170 Slater Street

UDRP Report and Response to UDRP Recommendations
April 10, 2024

**RE: Urban Design Review Panel Recommendation Responses
PC2023-0379
170 Slater Street – Site Plan Control**

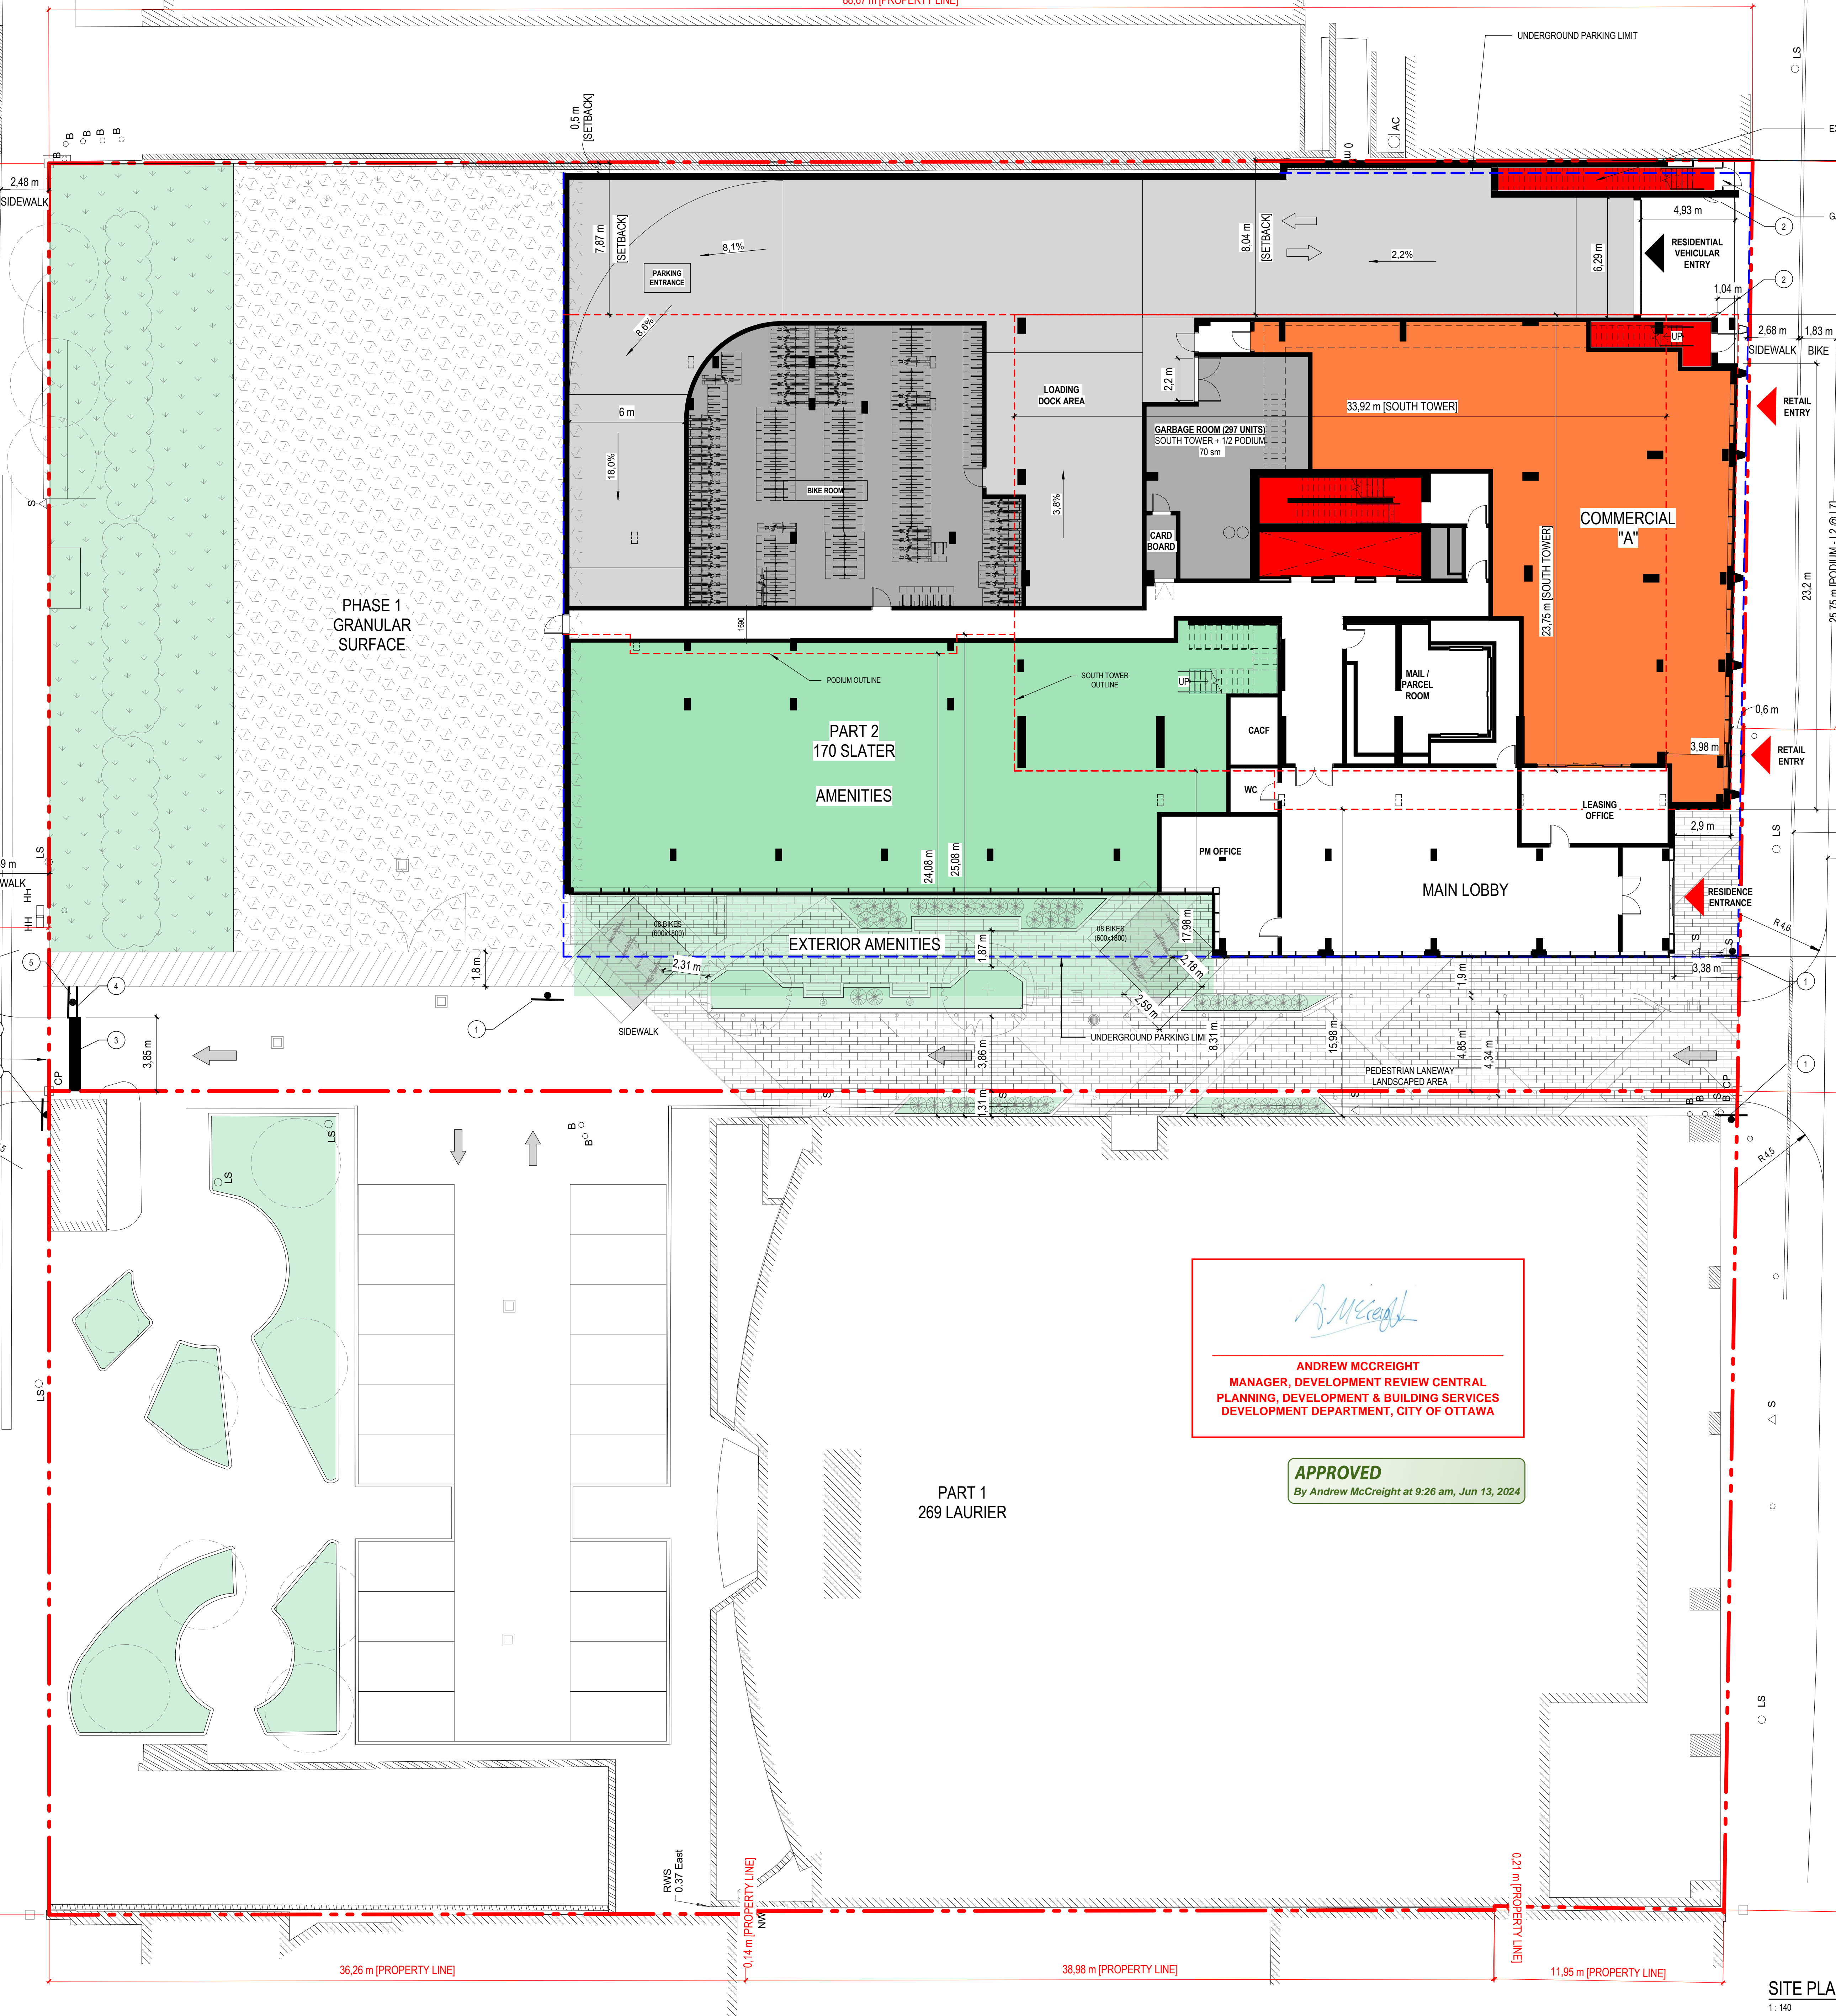
- 4 The Panel recommends further investigating how the existing parkette, future second phase, and the mid-block woonerf connect and how they holistically help to support the pedestrian uses on Slater Street. Perhaps a temporary POPS should be considered prior to Phase 2.
Please see the updated Site Plan for the intended condition of the Phase 2 building area prior to development.
